## Appeal Decision

**Appeal Ref: APP/R5510/D/23/3315342**

**School House, Clifton Gardens, Hillingdon, Uxbridge UB10 0EZ**

client: RUIN KHAYRI  
site: FORMERCARETAKERS LODGE CLIFTON GARDENS  
drawings: PROPOSED EXTENSIONS PLANS & ELEVATIONS  
scale: AS SHOWN author: now scale: MAR 22  
proj. no: N156 draw. no: P-01 revision: F

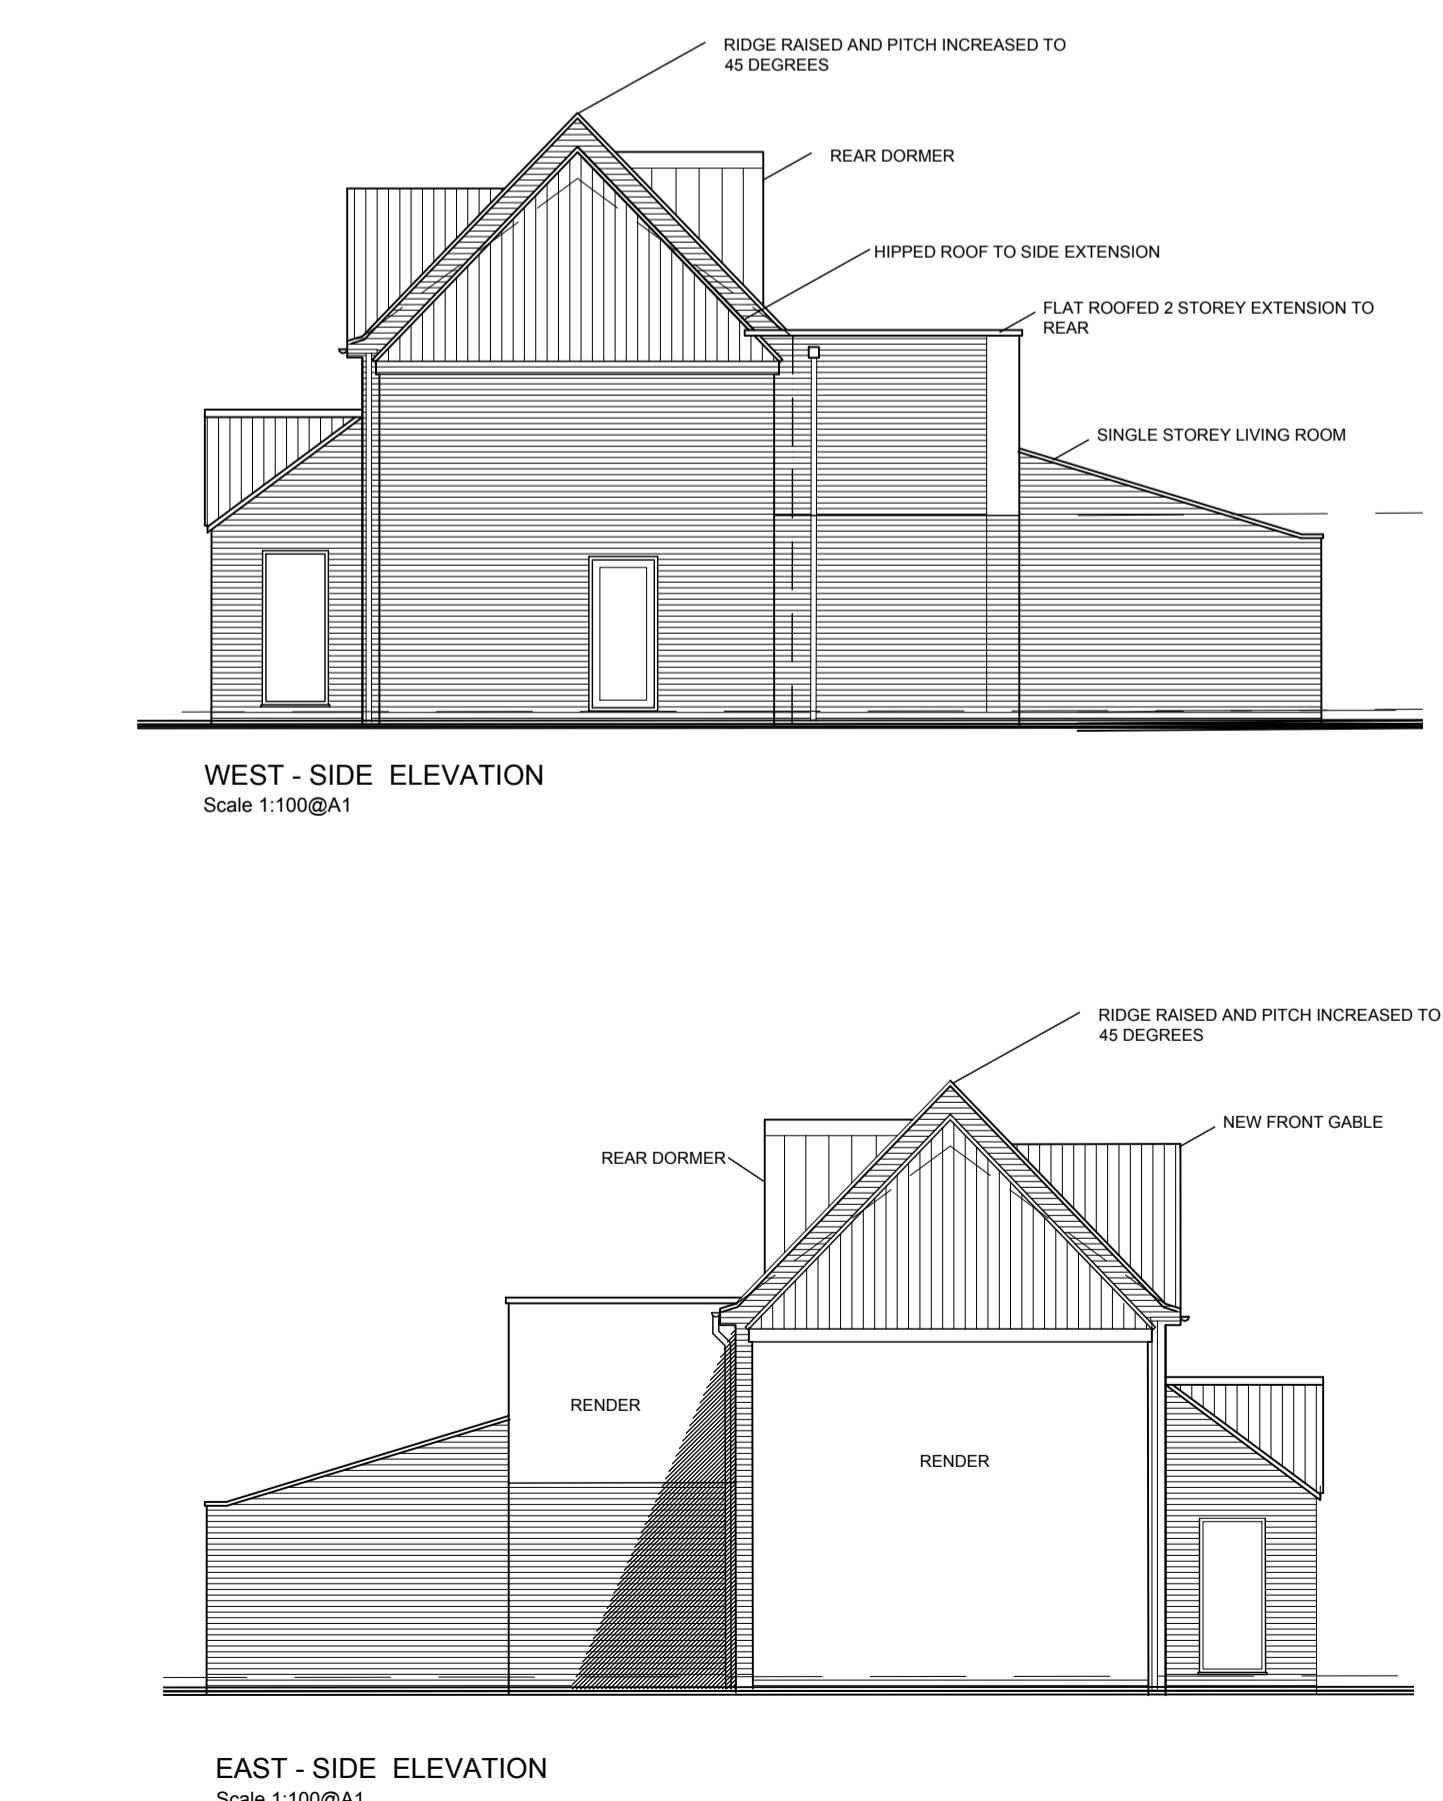
14. The proposed development would see considerable work to the property, including increasing its height to incorporate roof dormers and multiple two-storey, and single-storey extensions. In addition, the proposal would incorporate render and a predominantly glazed large front gable that would have a contemporary appearance.

16. However, the proposed two-storey side extensions would inelegantly elongate the dwelling in a way that would not appear subservient or subordinate to the host property. The staggered roof form would appear contrived and would not soften the presence of the bulky extensions, which would be a jarring form out of proportion with the host property. This would result in the extensions having a competing and overpowering impact when considered relative to the massing and scale of the existing property. As such, they would be unsympathetic to and at odds with the host building, even when taking into consideration that one side of the dwelling presently has a low-level side extension. This incongruous and jarring appearance would be highly visible along Clifton Gardens.

17. Additionally, the two-storey rear extension given its scale and positioning in conjunction with the side extensions, would not respect the modest architectural form of the building and would introduce a discordant addition that would be highly visible from the playing fields, service yard and car park to the rear.

18. Taken as a whole, the extent of works, wrapping around much of the building, would be significantly at odds with the host dwelling in terms of its form, scale, massing and use of materials. It would therefore fail to respect the existing property. Additionally, the sharp contrast between size, scale, massing and contemporary design with nearby dwellings' more traditional architectural styles would be an unsympathetic and harmful change to the street scene. This harmful effect is not overcome by the presence of the nearby educational building, which despite its scale and form, has a functional appearance associated with its use.
